Your Ref :
Our Ref : R/41/19/NMA

Application for a non-material amendment following a grant of planning permission R/285/17/HH -
reduce conservatory in size and remove proposed juliet balcony & replace with window
89 Broadmark Lane, Rustington, ,

Drawing No. 217/542/3

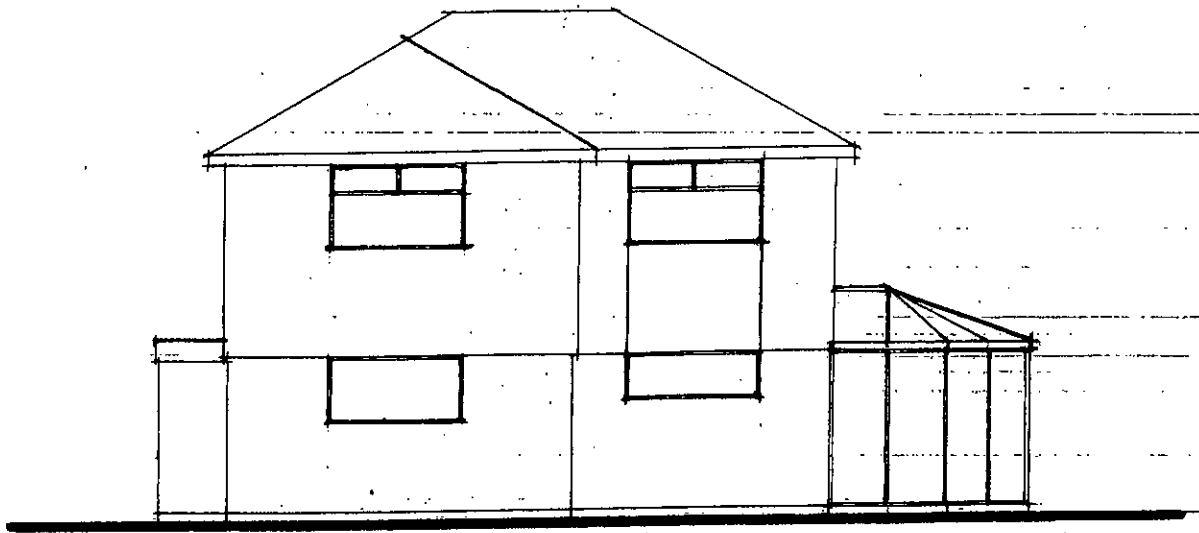
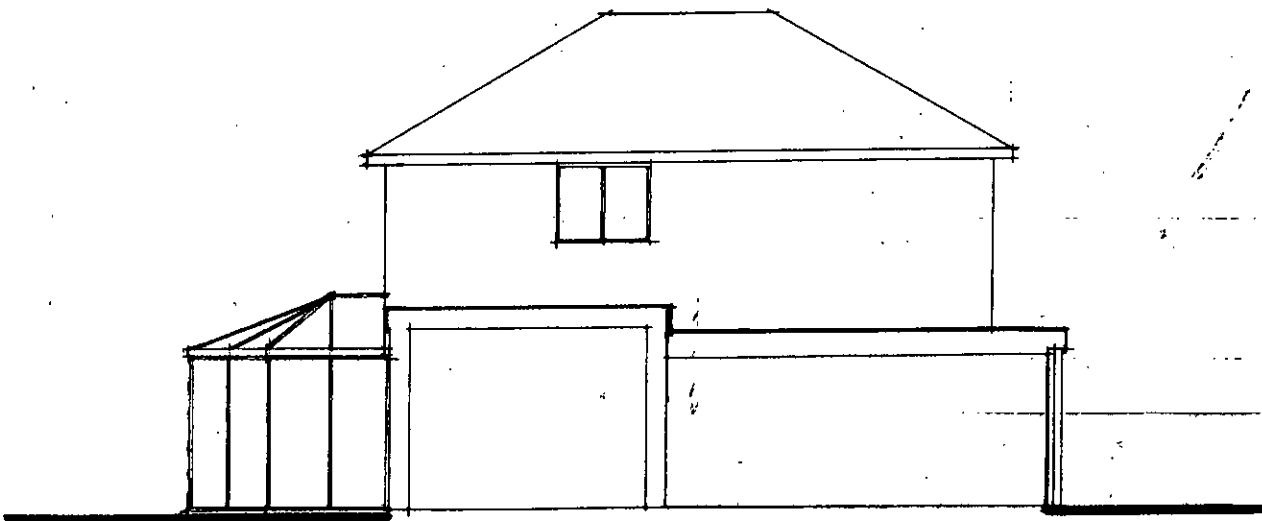
I refer to your recent application for a Non Material Minor Amendment. I note that you propose to reduce the proposed conservatory in size and omit the proposed Juliet balcony, and replace with a window.

Please note that the Drawing 217/542/3 now replaces 217/542/5 - Rev A of previously granted application ref: R/285/17/HH.
